Our Ref: WA/88/21/DOC

Approval of details reserved by condition imposed under ref APP/C3810/V/16/3143095 (WA/22/15/OUT) relating to Condition Nos 12 - surface water drainage, 14 - maintenance & management of SuDs, 15 - foul drainage, 19 - Construction Management Plan (to incl Construction Traffic Management Plan), 20(d) - forecourt layout & drainage & intensity of all lighting, 21 noise, 25 - Travel Plan and 26 - Non-Motorised Users Audit.

Arun District Council have decided to **REFUSE details reserved by condition for the following reasons:**

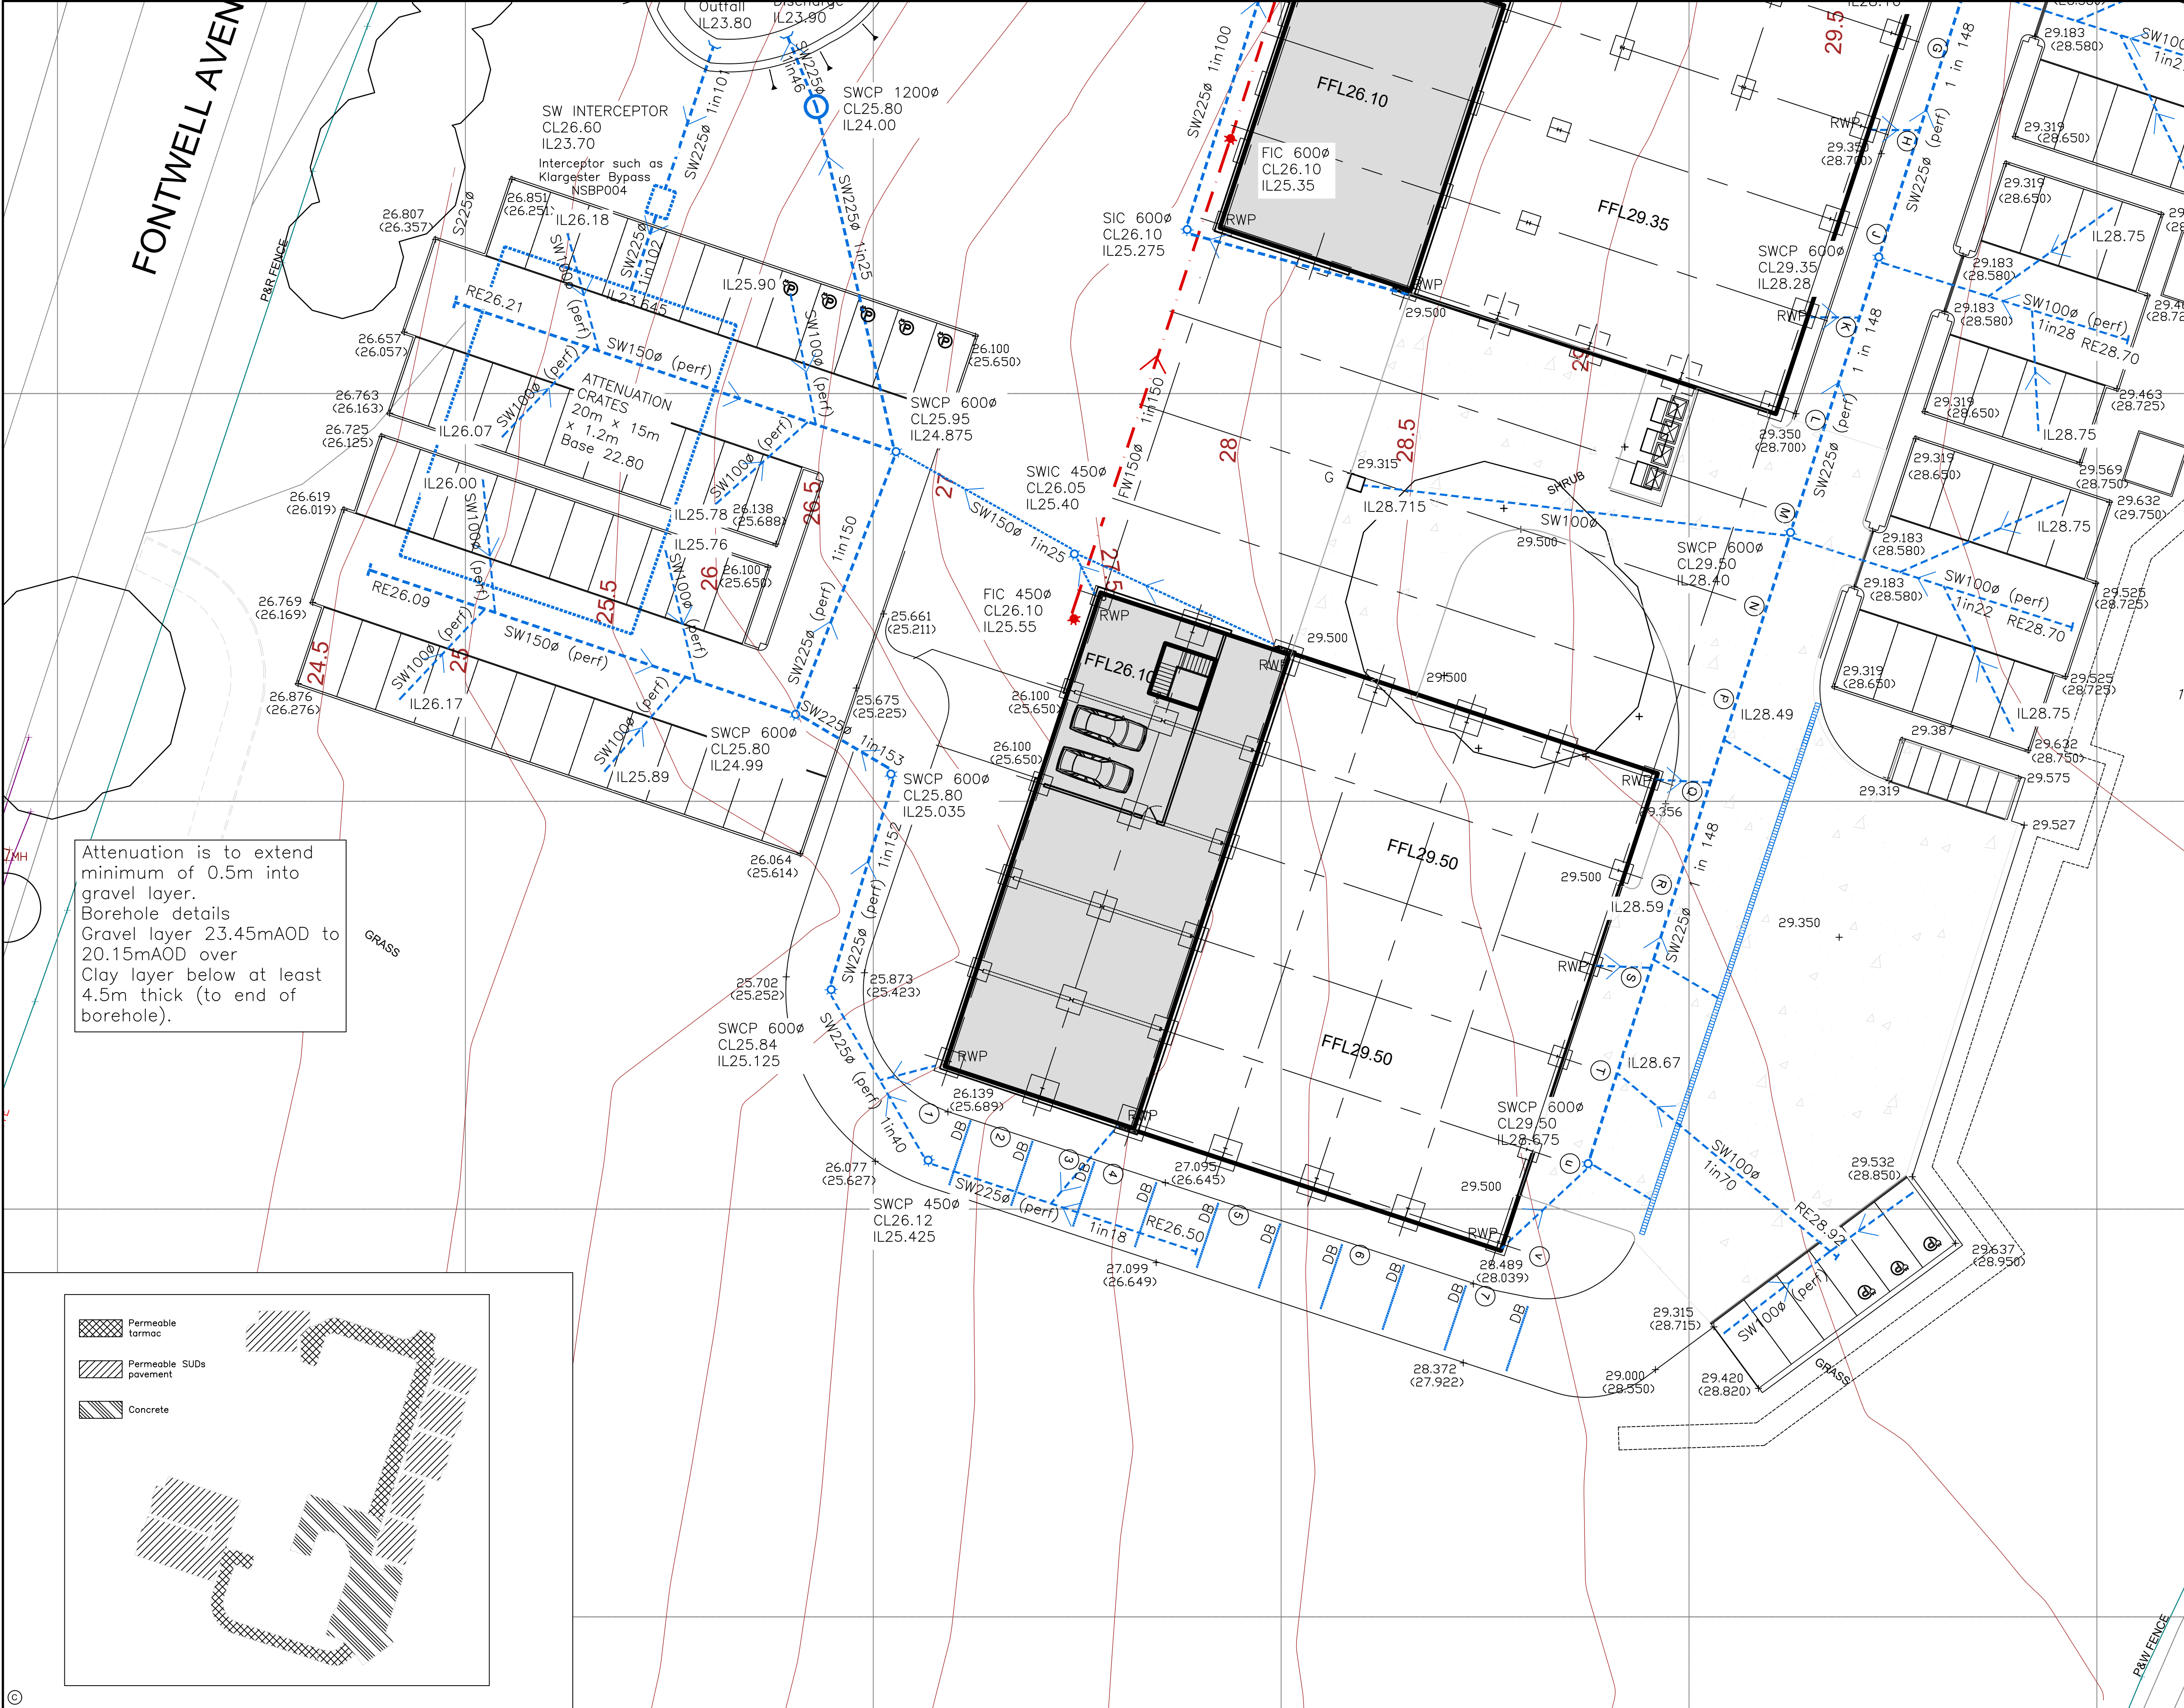
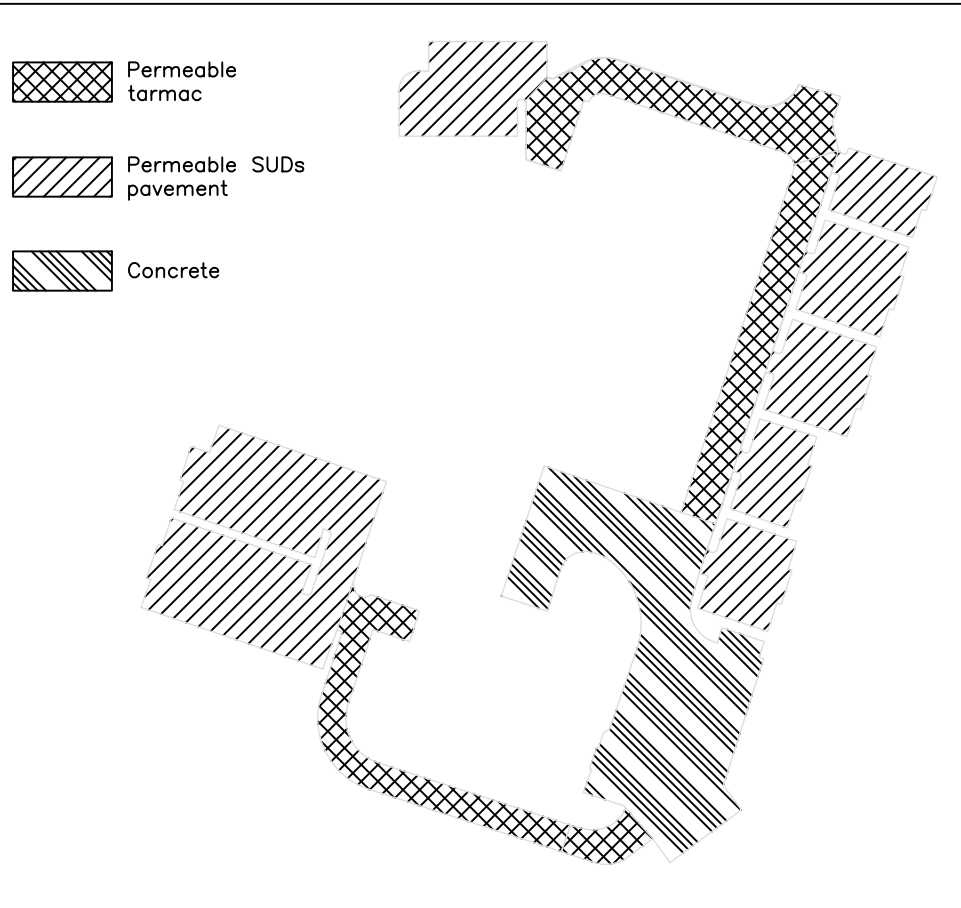
1. Permeable paving extents are not very clearly shown, a small insert layout is provided on one layout only. Permeable paving extents should be clearly shown on all layouts.

2. Catchpits still have not been provided upstream of connections into permeable paving sub-base. Stating that there will be filter socks is insufficient. We acknowledge that the filter socks will prevent silt ingress into the sub-base, however over time the permeability of the filter material will decrease as silt builds up on it, with no easy means of maintenance.

Attenuation Pavement and Perforated Pipe Detail

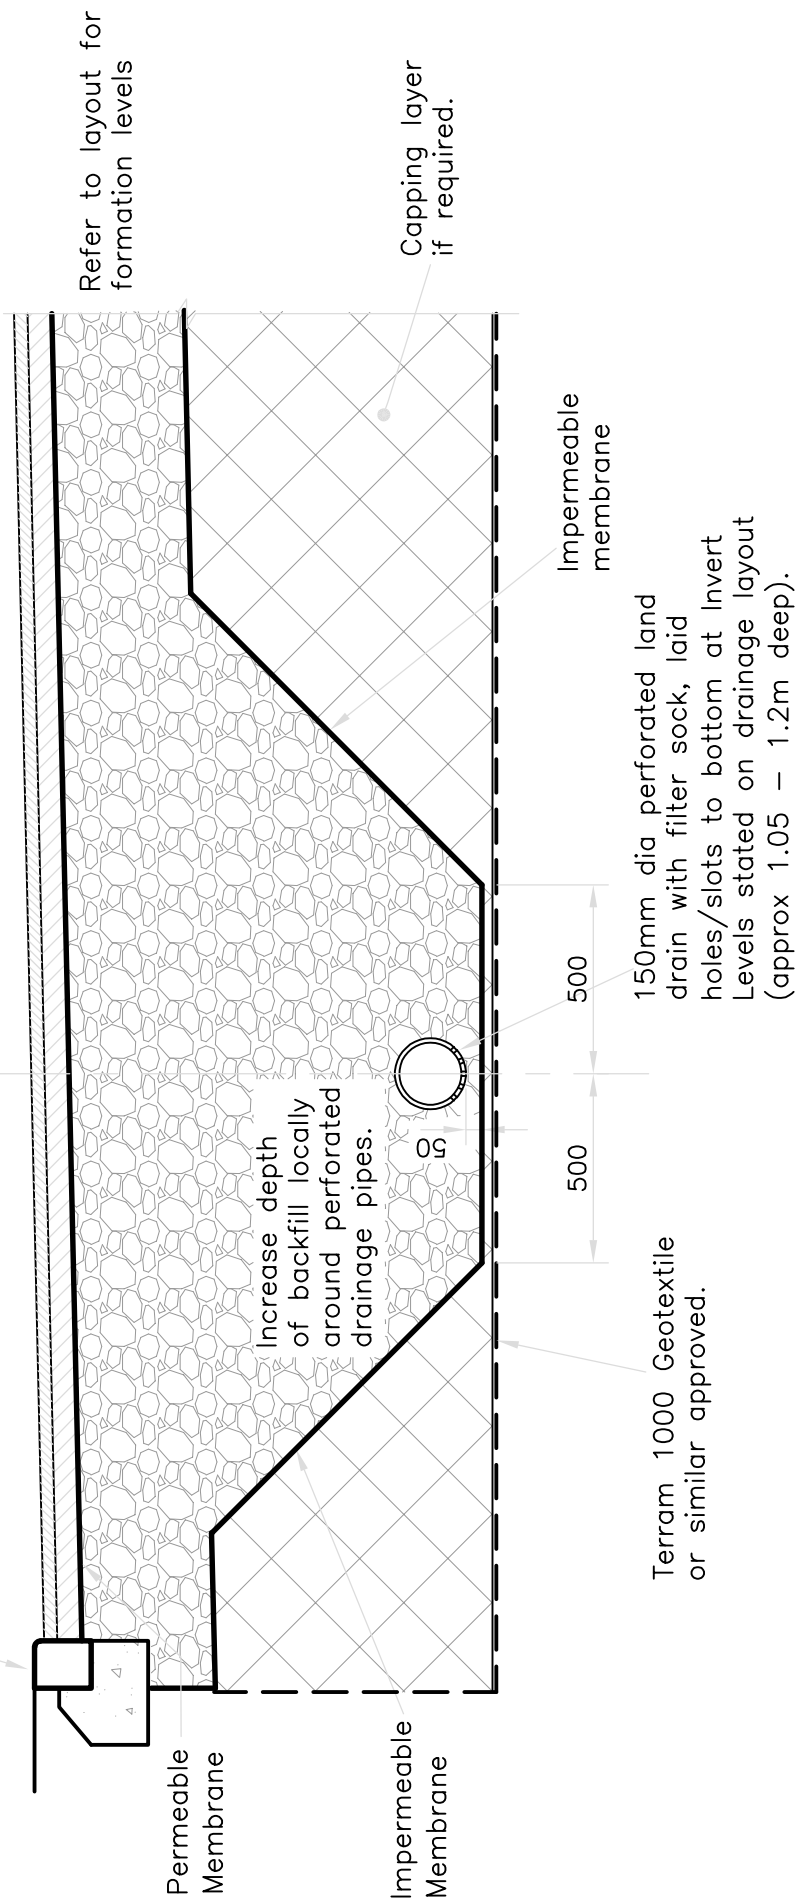
3. It is not possible to review if appropriate cap volume depths have been applied to calculations without a more detailed construction detail drawing of the permeable paving.

5. Permeable paving construction detail drawing should fully detail the entire construction.

Typical Flow Control Details

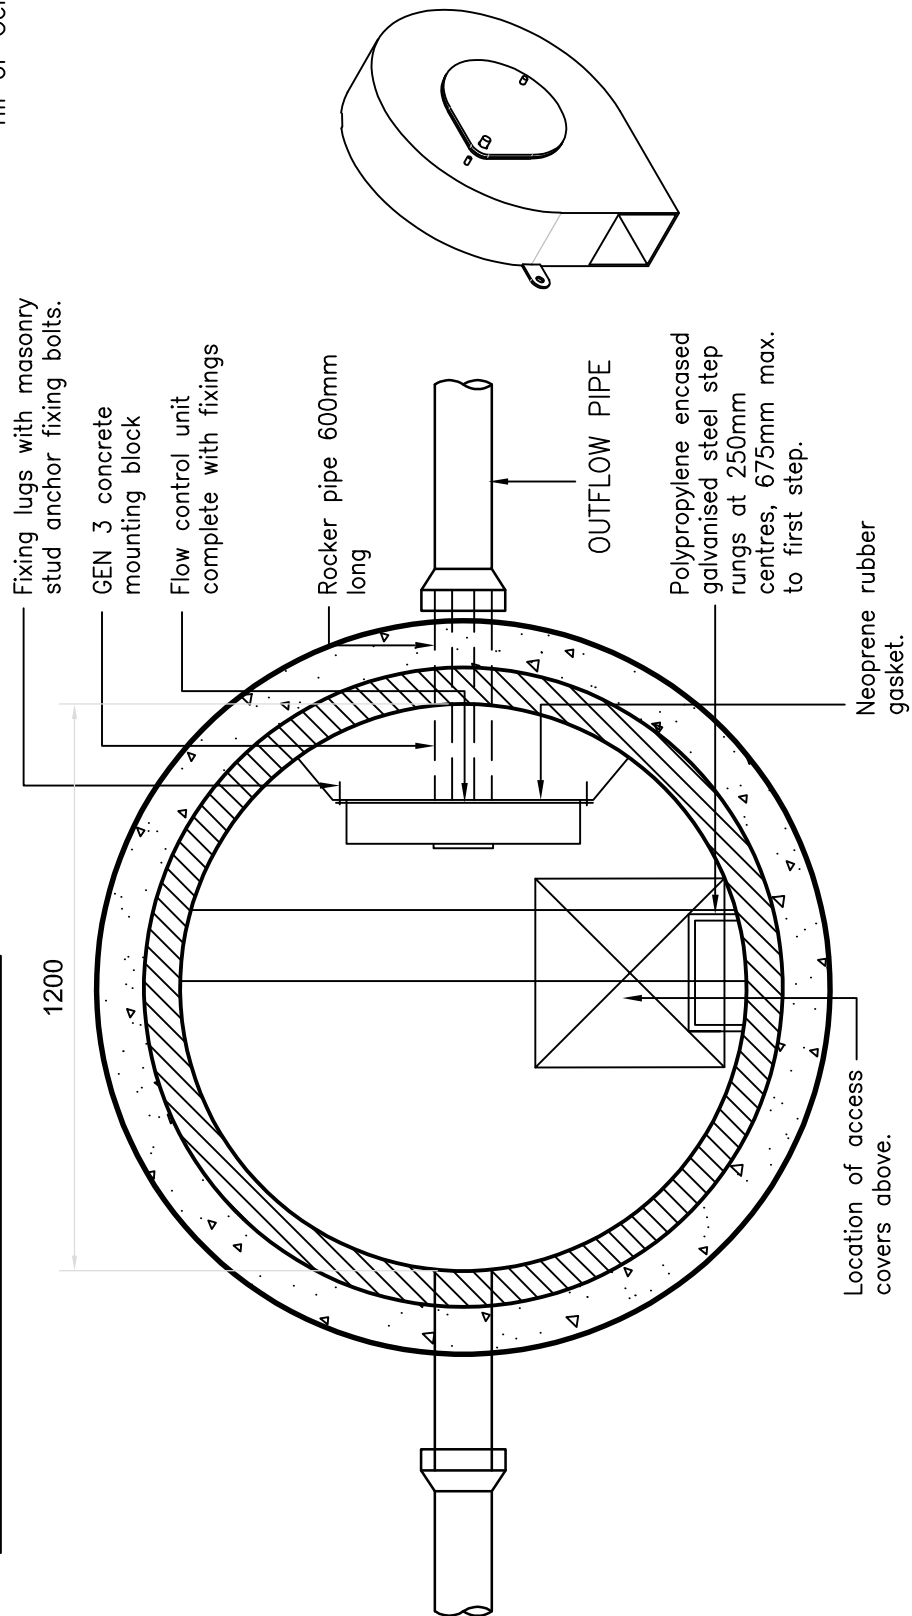
4. Construction detail drawings should be site specific. So there should not be a hydrobrake included on details. Construction details of the infiltration basin should be provided including the headwalls into this.
